Your Ref: OWPC6402
Our Ref: M/56/15/HH 15-05-2015
Please ask for:
Ross Leal

Side & rear extensions
31 Sea Way Middleton-on-Sea

*Application M/56/15/HH
31 Sea Way, Middleton-On-Sea, West Sussex, PO22 7RZ*

ROOF PLAN
1.100

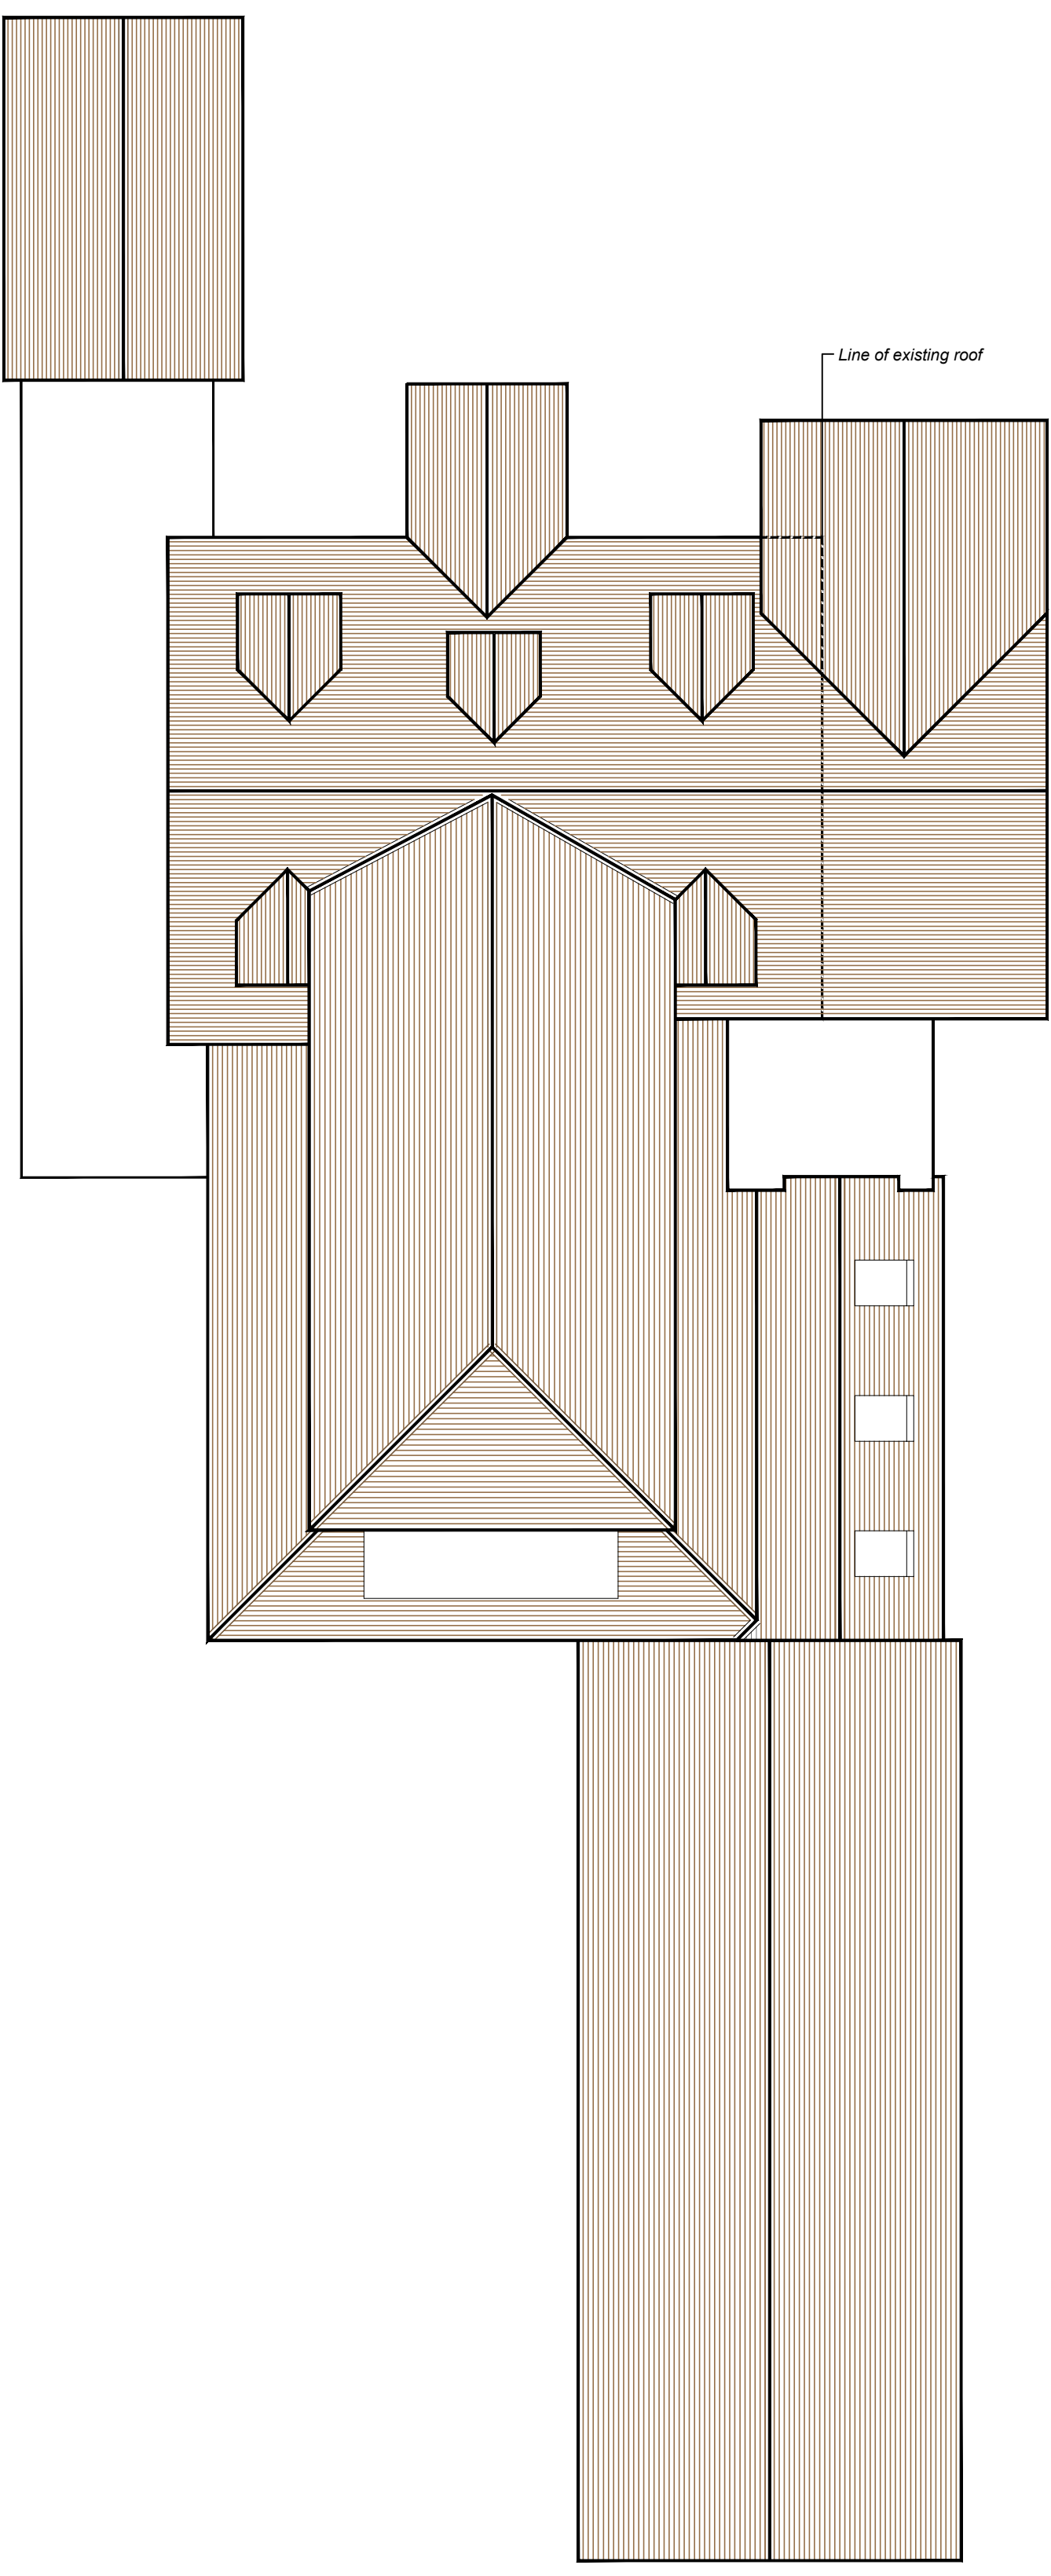
We write with reference to the amendments that have been made to the above proposal. We still feel that, even with the small reduction in height of the proposed swimming pool cover, the overall application represents a massive overdevelopment of the site. Since our first objection we have become aware of how the structure will look from upstairs at Number 29 & it simply not pleasant to inflict such a view on a neighbour. We believe it will be fully visible from the Greensward & will spoil the rural aspect from there considerably.

We believe there is an easement of 3 metres along each side of the improved drain. It would be beneficial to all concerned if a plan could be produced to show the proposed construction in relation to the drain. From the plans we have seen for the pool enclosure we believe that this 3 metre easement will be compromised. If this is the case there must be no question of planning permission being granted.
